Application 6/2021/3172/FULL

I have received notification from you of a further application by the occupants of 51 Kentish Lane for a change of use of the property from a dwellinghouse to a mixed use as a dwellinghouse and a commercial film set.

Project:	51 Kentish Lane Brookmans Park AL9 6NG	Drawn By:	AEH
Drawing Title:	Site Plan Lighting Exclusion Zone	Date Drawn:	03/02/2021
Scale:	1:500 (A3)	Drawing Number:	TDC058/PL2/001
Rev:	-	Rev:	-

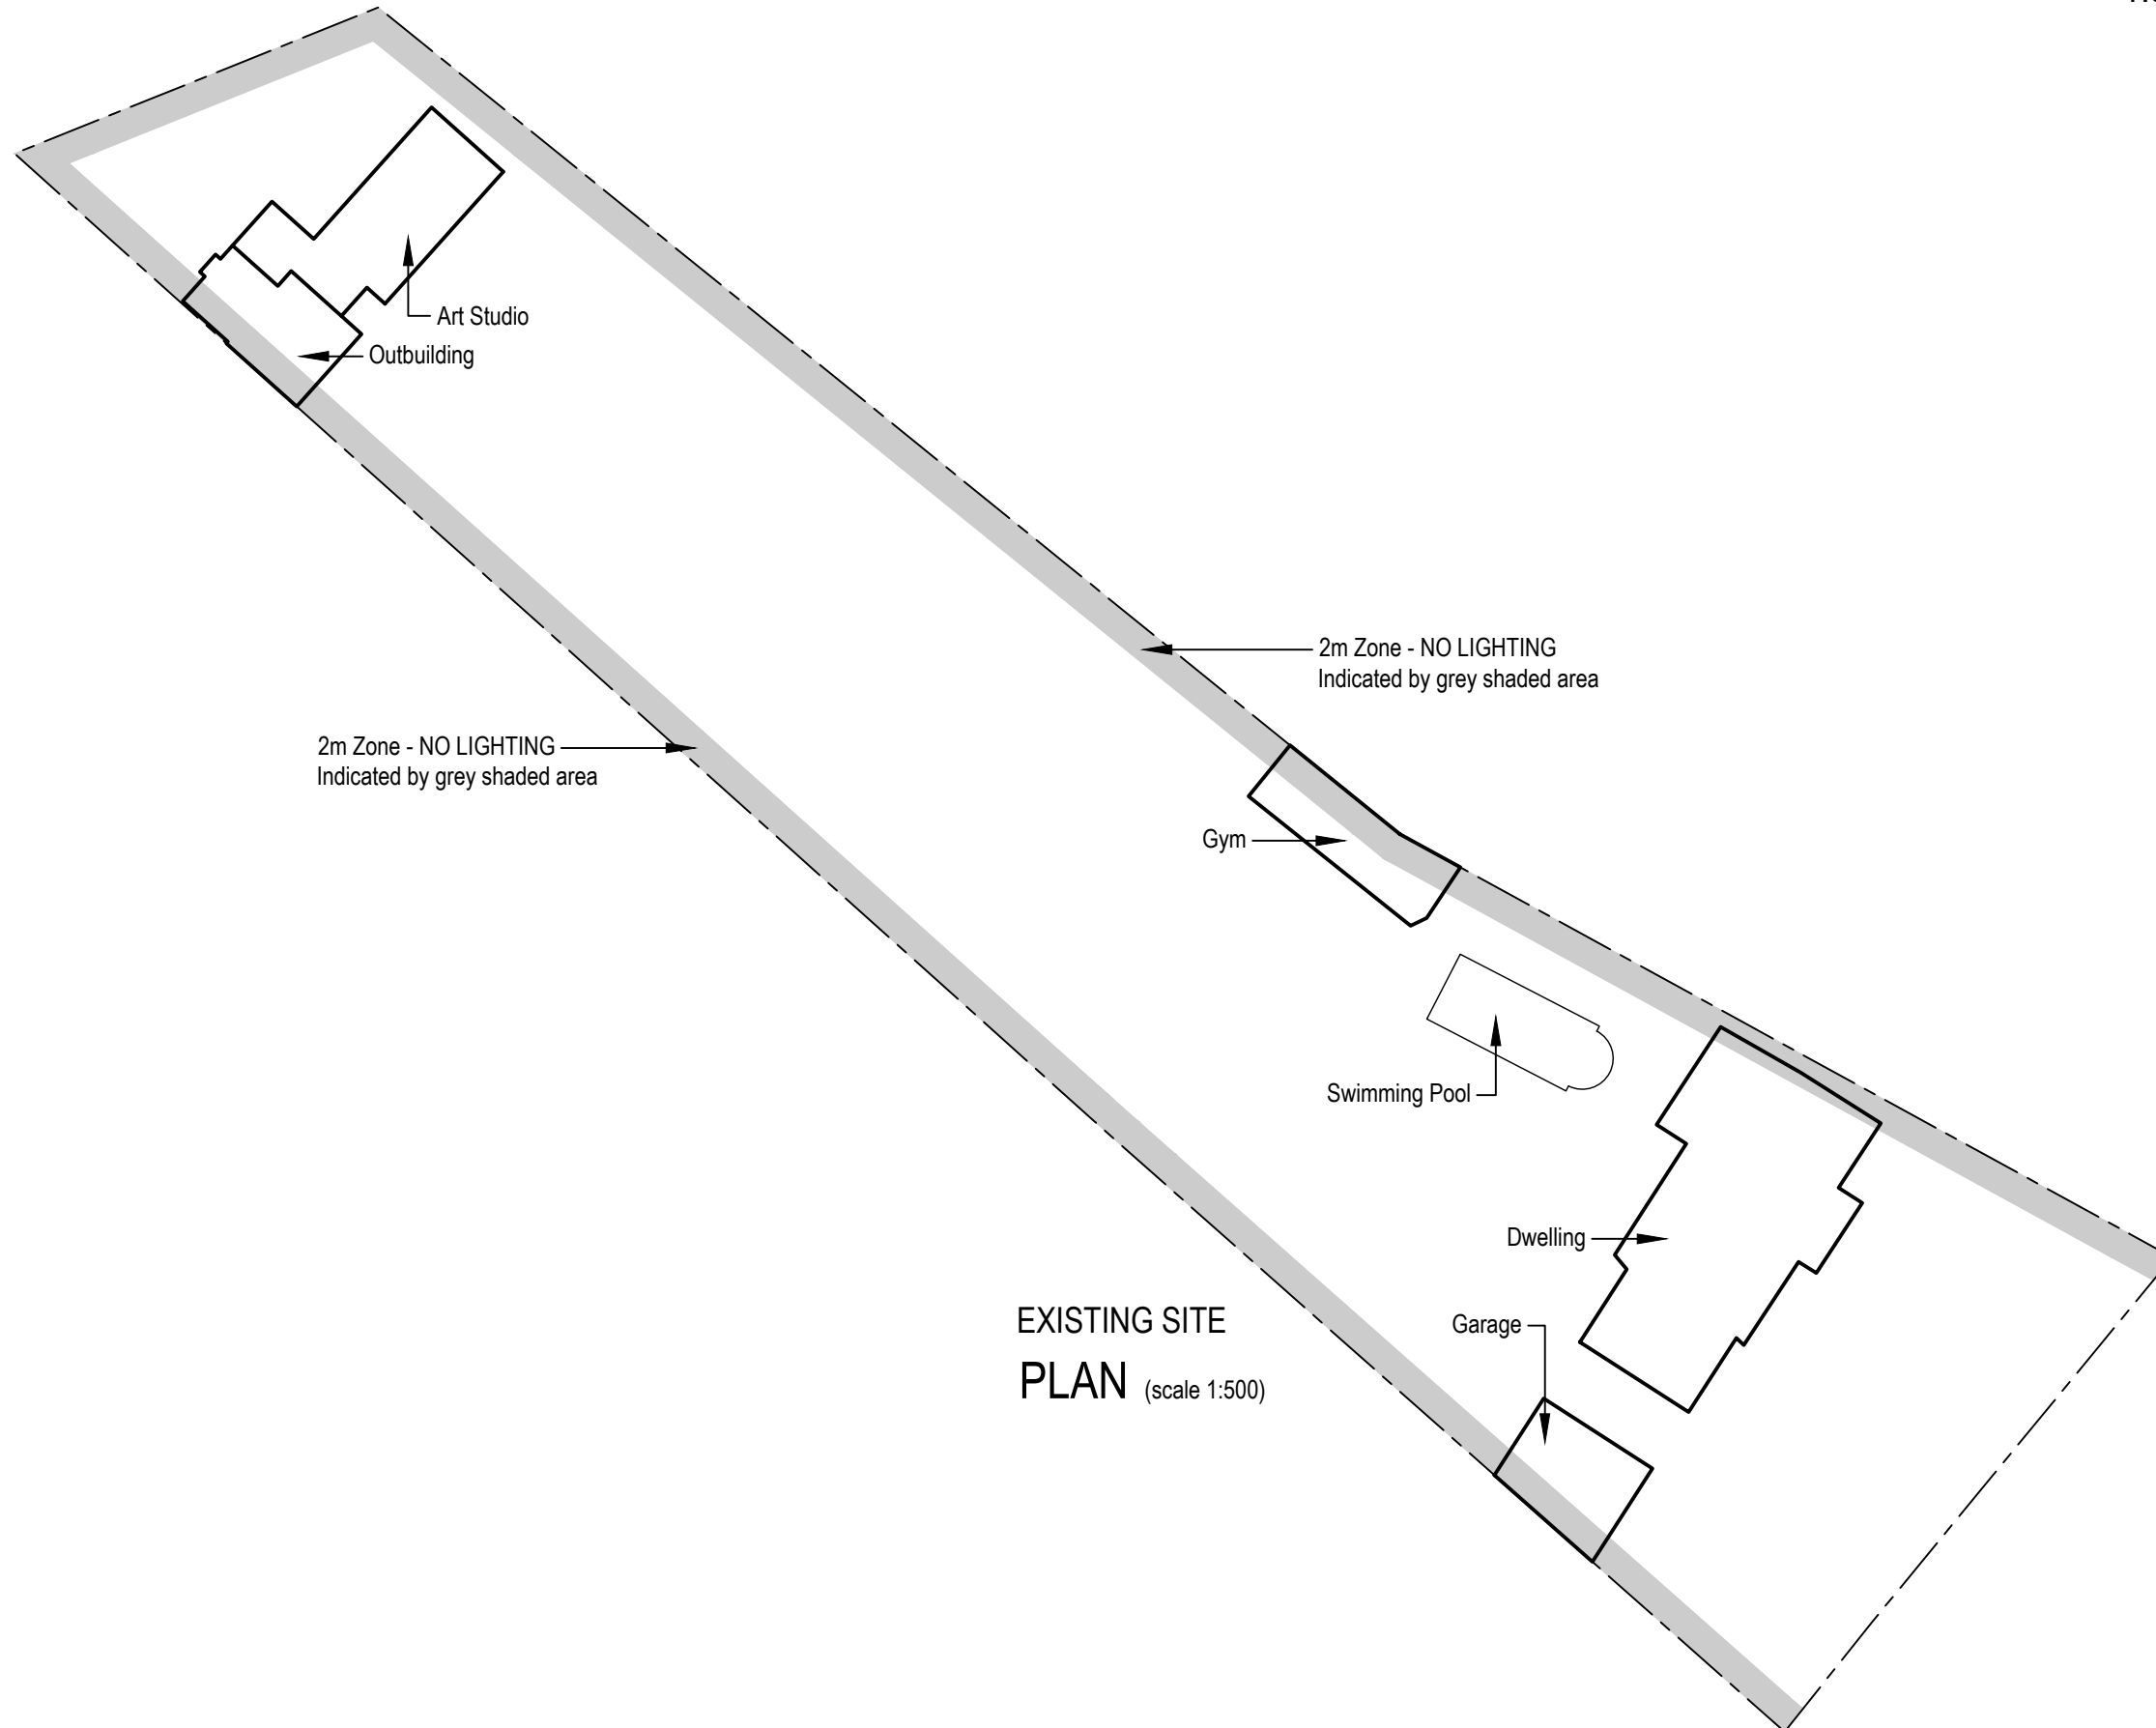
Paragraph 4.26 of the Planning Statement refers to limitation of lighting and measures taken to prevent light-spill and refers to the presence of dense conifer planting exceeding 10m in height on the boundary. While it is correct that the owners of No 51 have allowed dense conifers to grow on their boundary to a height of about 6 -10m and that this may mitigate visual intrusion, it is at the expense of permanent shading and effect on vegetation in the adjoining properties.

DRAWING TITLE  
**Potential Parking Space Arrangements**

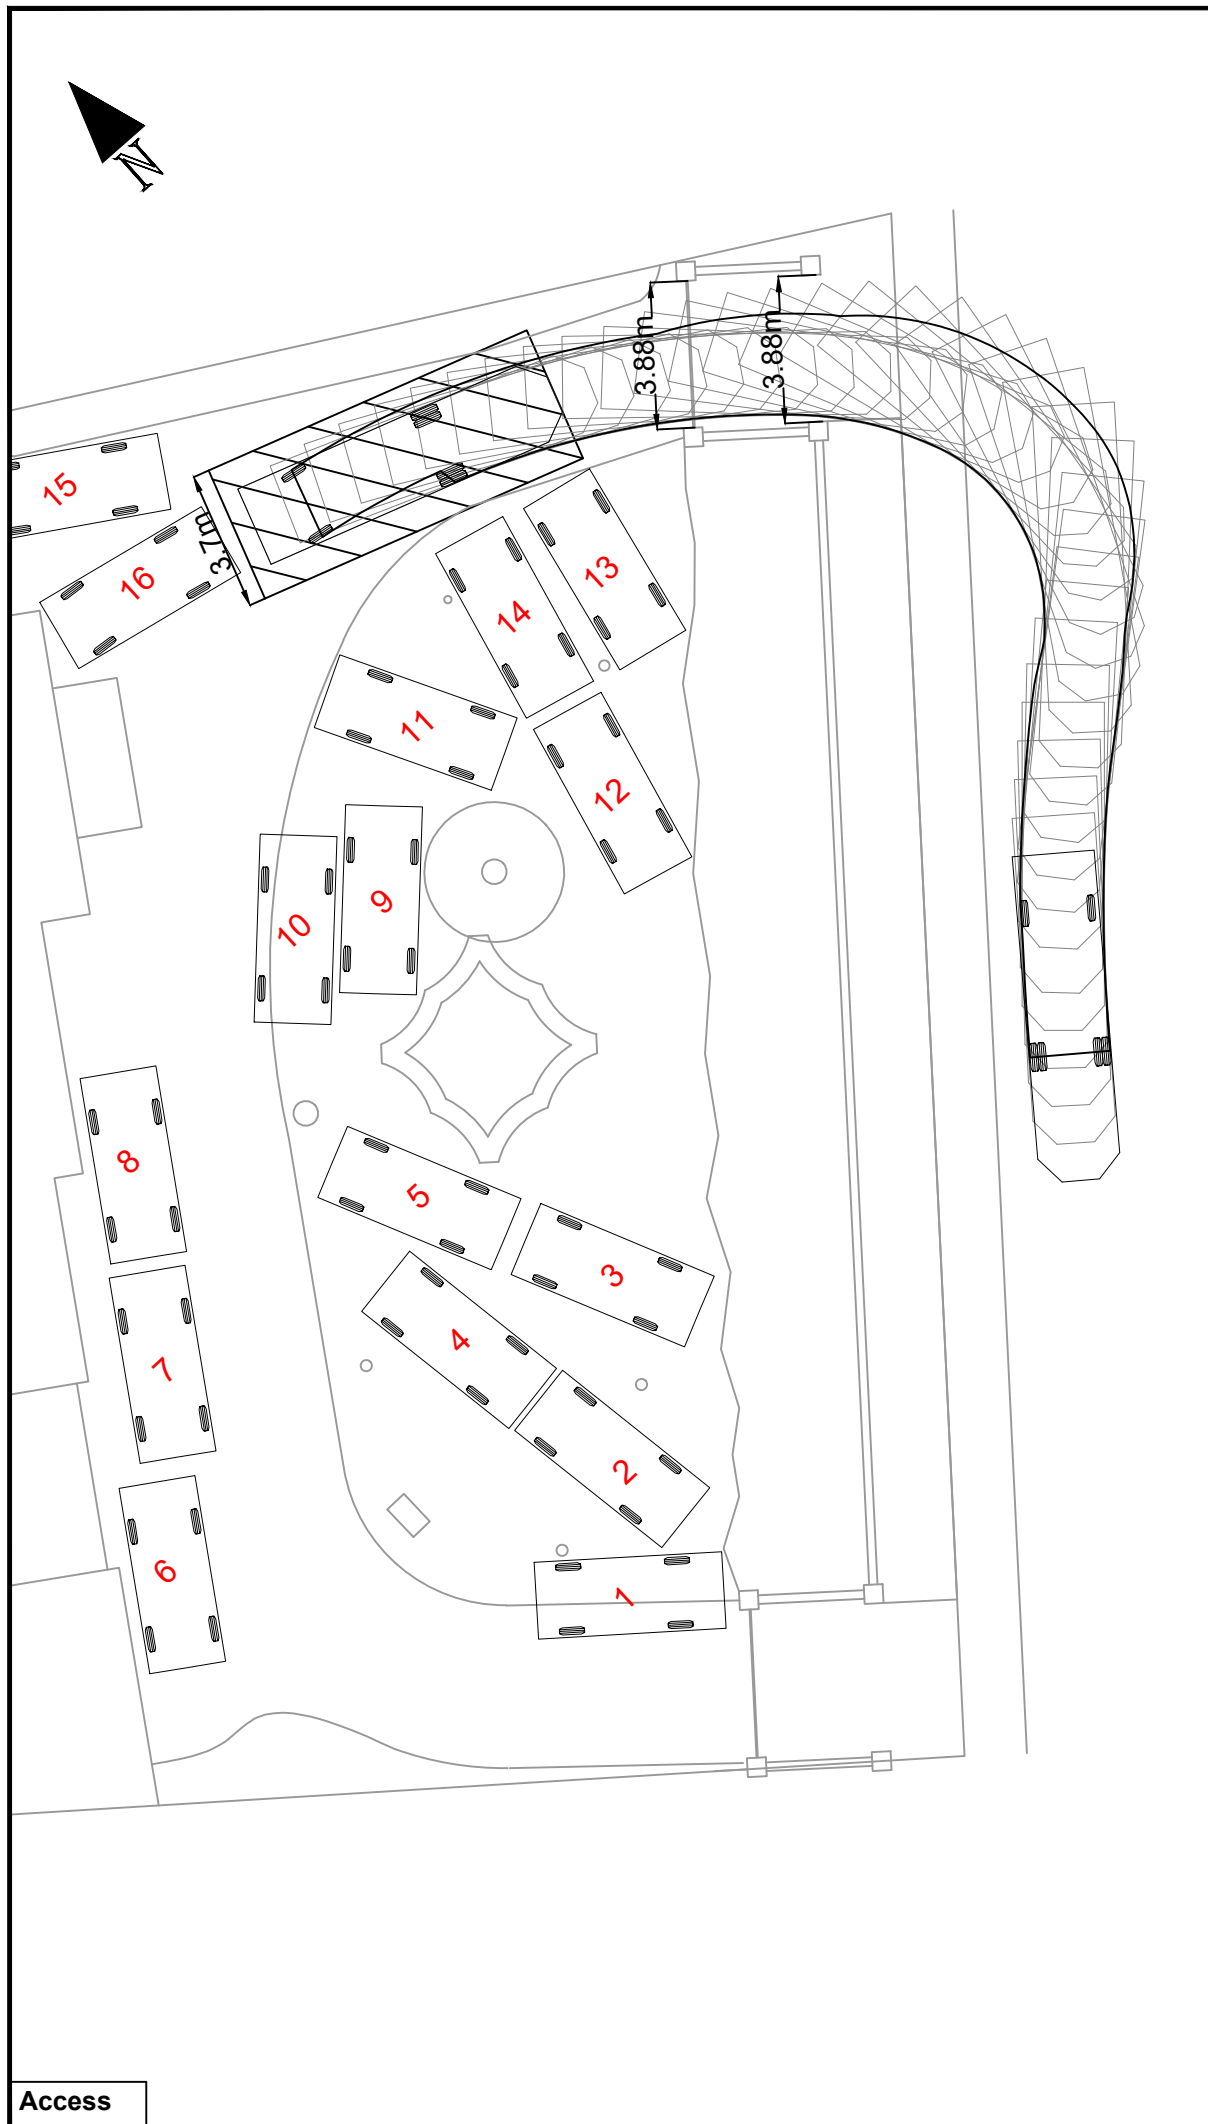
The Events Management Plan is stated to have been submitted to the Highway Authority, showing the intended parking provision in the front garden and limiting filming to the rear garden. The submitted parking plan is said to demonstrate how 20 cars can be parked with room left for a minibus or a van to enter and leave the site. This is an increase in the number of cars which the site was claimed to be able to accommodate in the previous application. I suggest that the applicant be required to physically demonstrate the viability of the parking arrangement and how it would be managed since on the face of the submitted drawing, no provision has been made e.g. for opening car doors. It is assumed that the gates to the property will be open during filming since there is no provision indicated for the inward opening gate swing.

- 2.3 Event recording: this should include the set-up and dismantling times in a similar manner to the actual filming times.
- 2.5 See previous comment regarding conflict with school traffic at 07:30 am
- 2.7 See previous comment, definition of an “activity period” is required
- 2.8-2.22 Viability of on-site parking to be demonstrated. The indication by the Highway Authority in the Pre Application letter that the parking appears viable refers to a different drawing and different number of parked vehicles.
- 2.24 To clarify if the 45m limit for fire brigade access referred to in the context of a house is also intended to apply to a film set in the rear garden in which case is there a limit on the extent of rear garden deemed safe for filming.
